Re: Planning Application BE/84/19/PL

Site 6, North Bersted

OBJECTION

4.3 LANDSCAPING

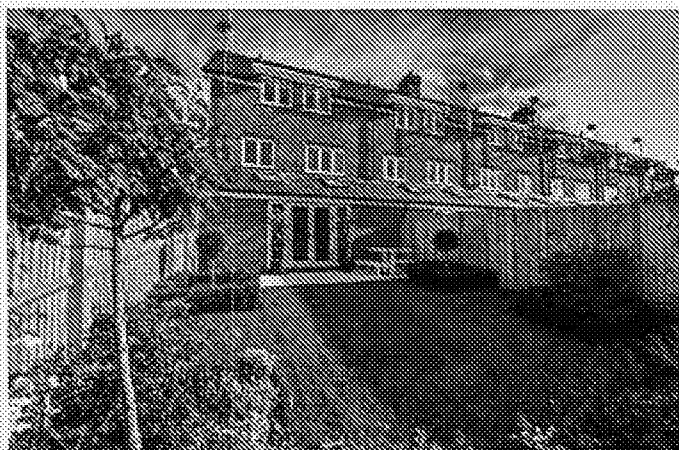
Another error in the DAS is the reference to the application being accompanied by a detailed landscaping scheme – no such scheme has been submitted

DRAWING TITLE
SITE LAYOUT - PHASE 4c

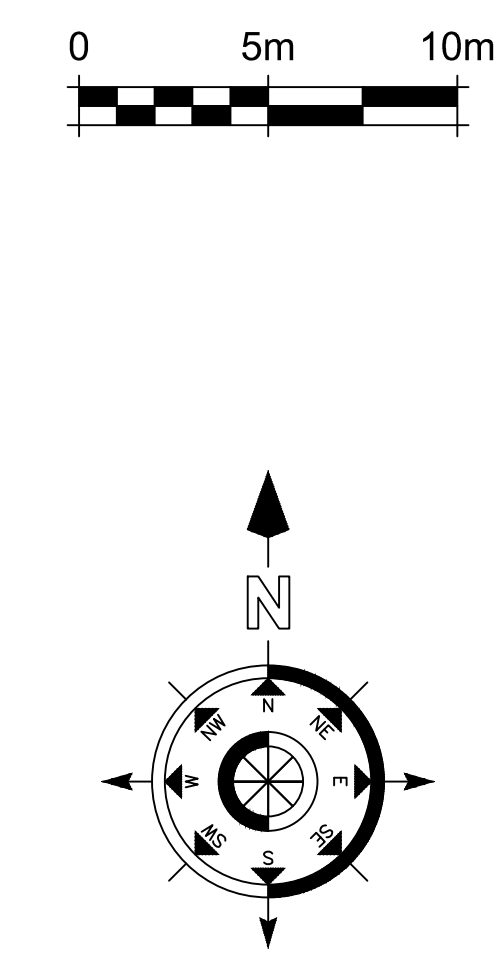
As with the landscape belt behind 346-350 Chichester Road the western landscape belt must NOT be included within the garden of any property and it must be fenced off with a 1.8m high panels fence. This guarantees its long term retention for this purpose. If it is included in a garden it will be likely that over time it will be thinned or cleared and its function will diminish or disappear.

The western extent of the hedgerow currently aligns with the eastern side of the temporary footpath and this must form the line of the new fence. This alignment is slightly further west than the western edge of the footway in front of plots 606-610.

We have attached an enlarged copy of the submitted site plan indicating where we consider the protective fence should be erected. That said this is an old plan as the parking for plots 328 etc was moved further south into the rear landscape belt without consent some years ago – this is self evident from the Google Earth photograph from this year as shown below.
